Demolition of existing dwelling & erection of 1 No. dwelling, associated landscaping & parking (resubmission following K/11/16/PL).

Spring Tide Gorse Avenue East Preston

Thank you for your internet representation made on 2nd March 2019 which has been recorded as **'an objection'** with the comments as follows:

Drawing: Existing Site Plan
Dwg No: 247-D-01

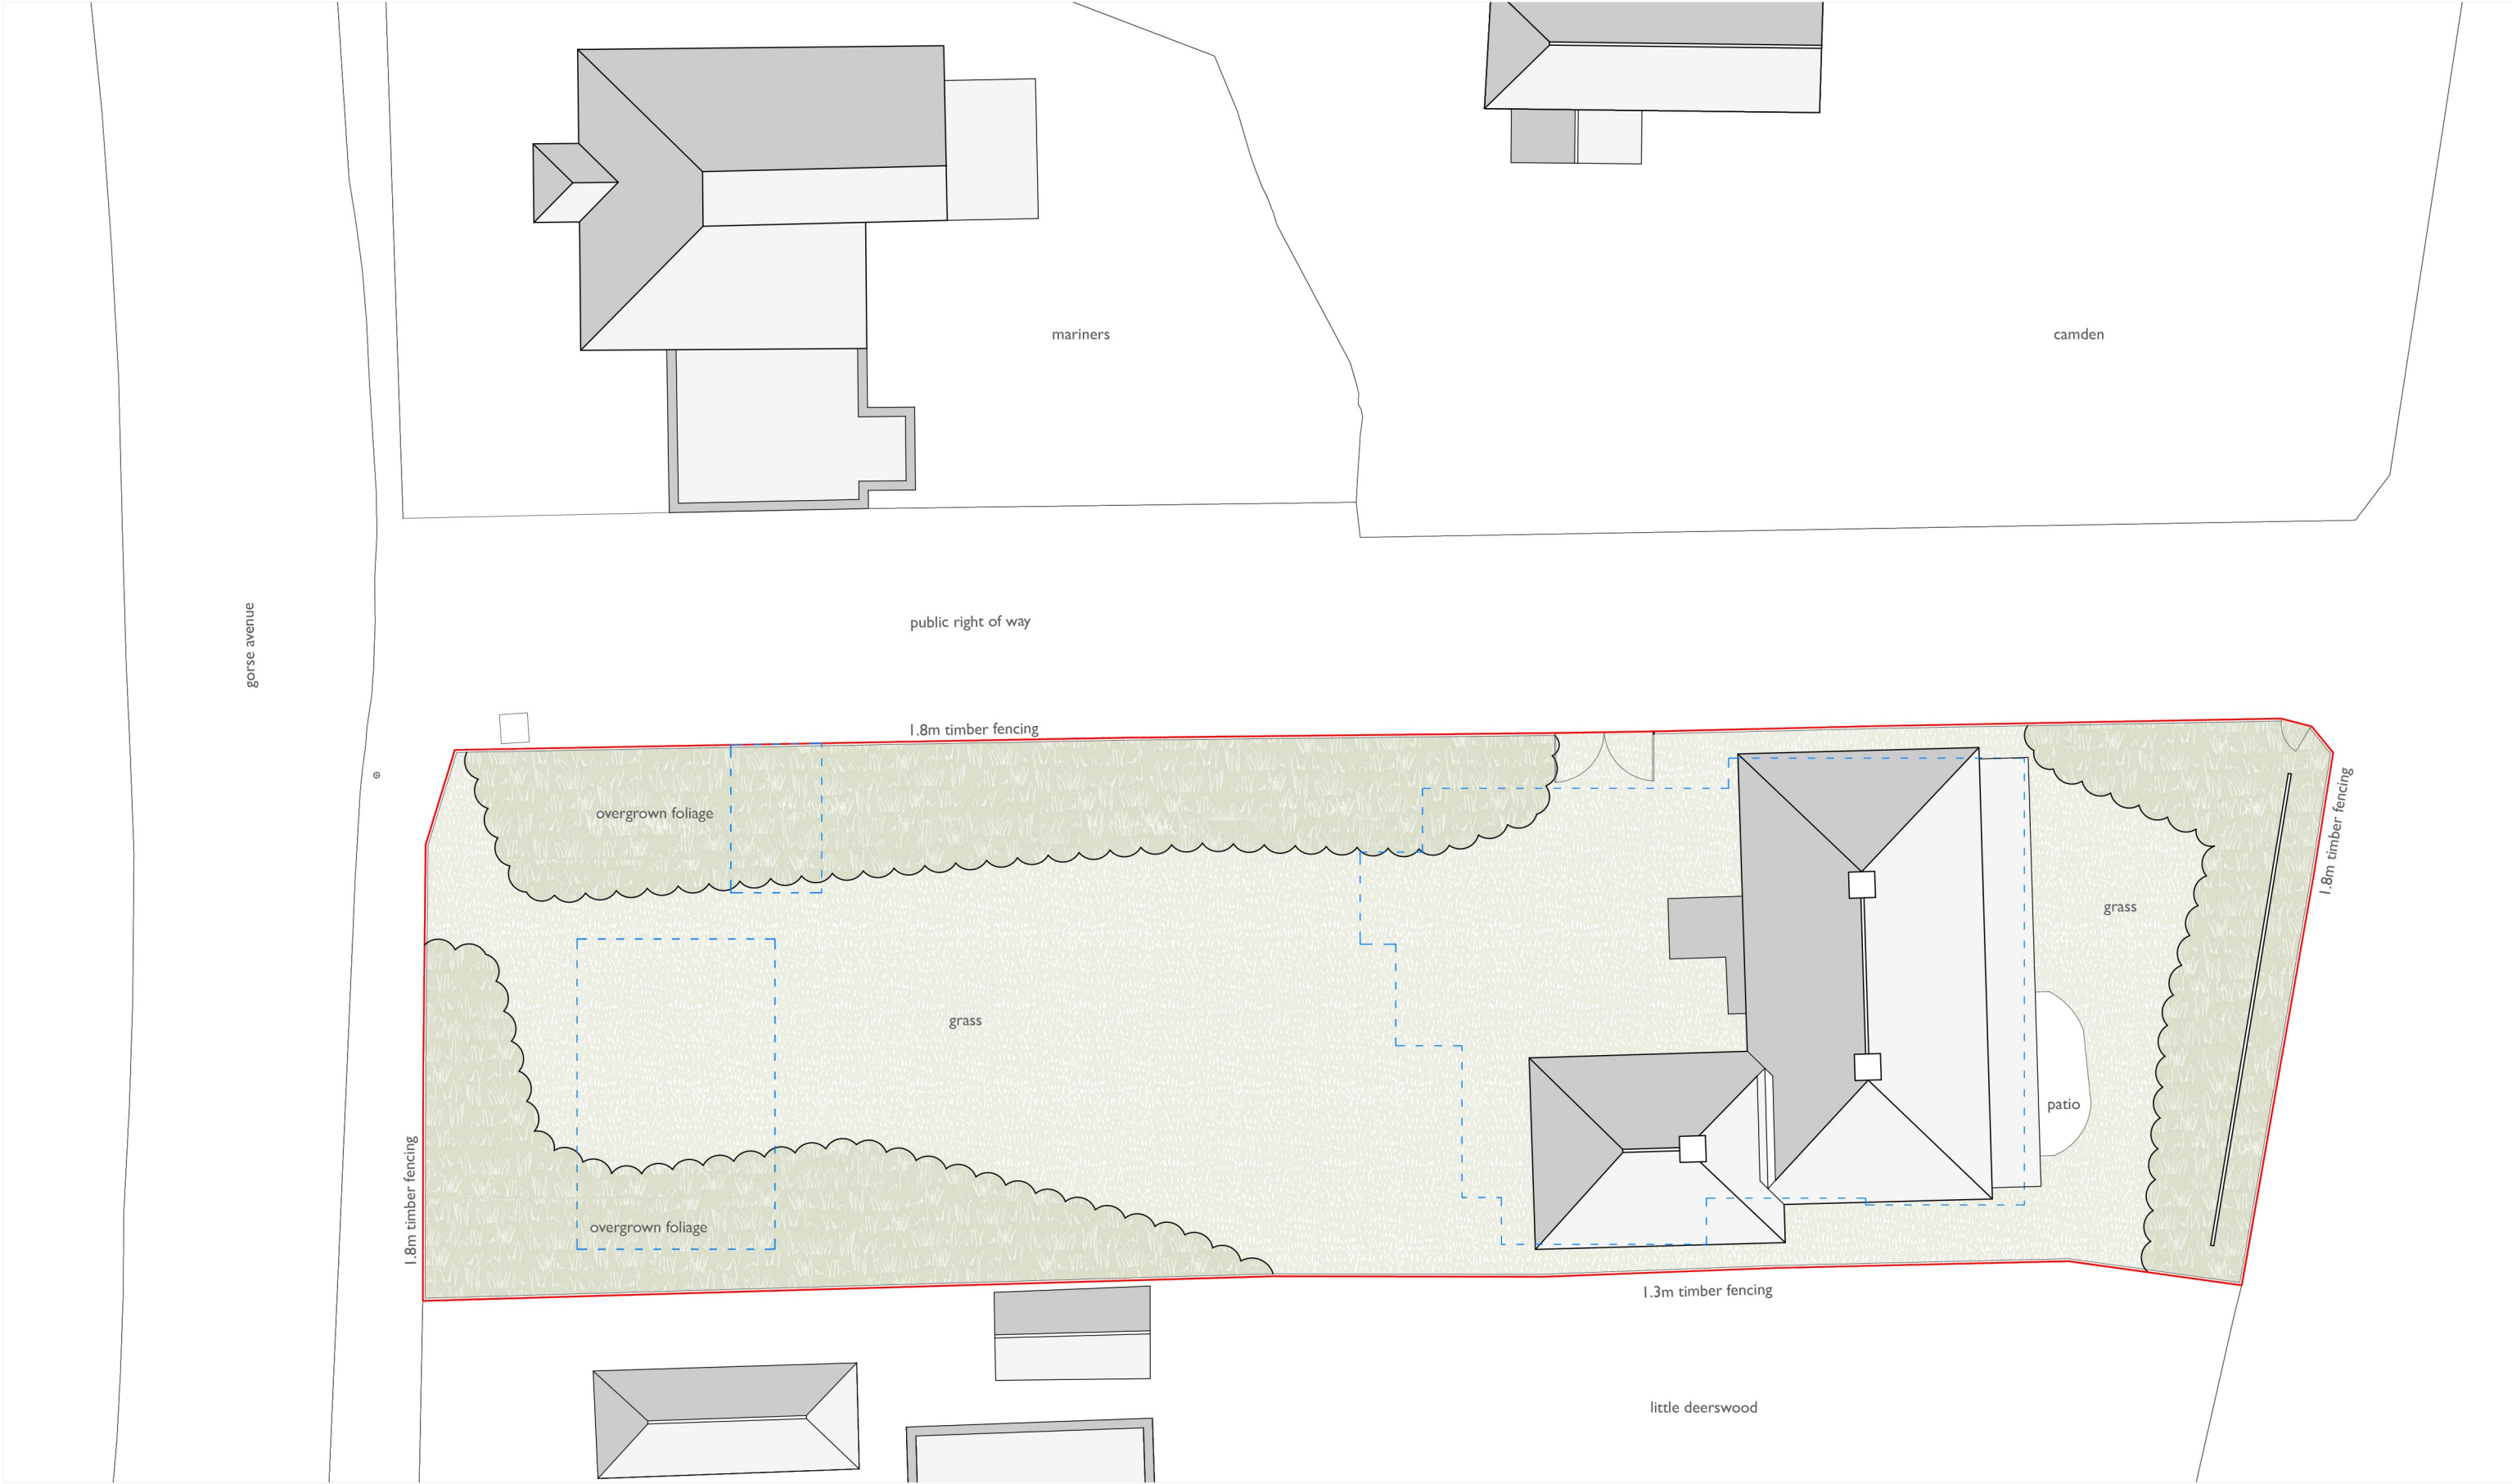
Please also note that in the site location plan 247-D-Rev B the outlined block for Mimosa is shown to run up to the east boundary line. This is incorrect, as there is a distance of 4.8 m between our property and the fence, unlike the proposed drawings for Spring tide which appears to run very closely to the boundary line and will therefore result in a long three story high incongruous wall along the twitten. This would begin to change the rural setting of the estate to that of an urban development.
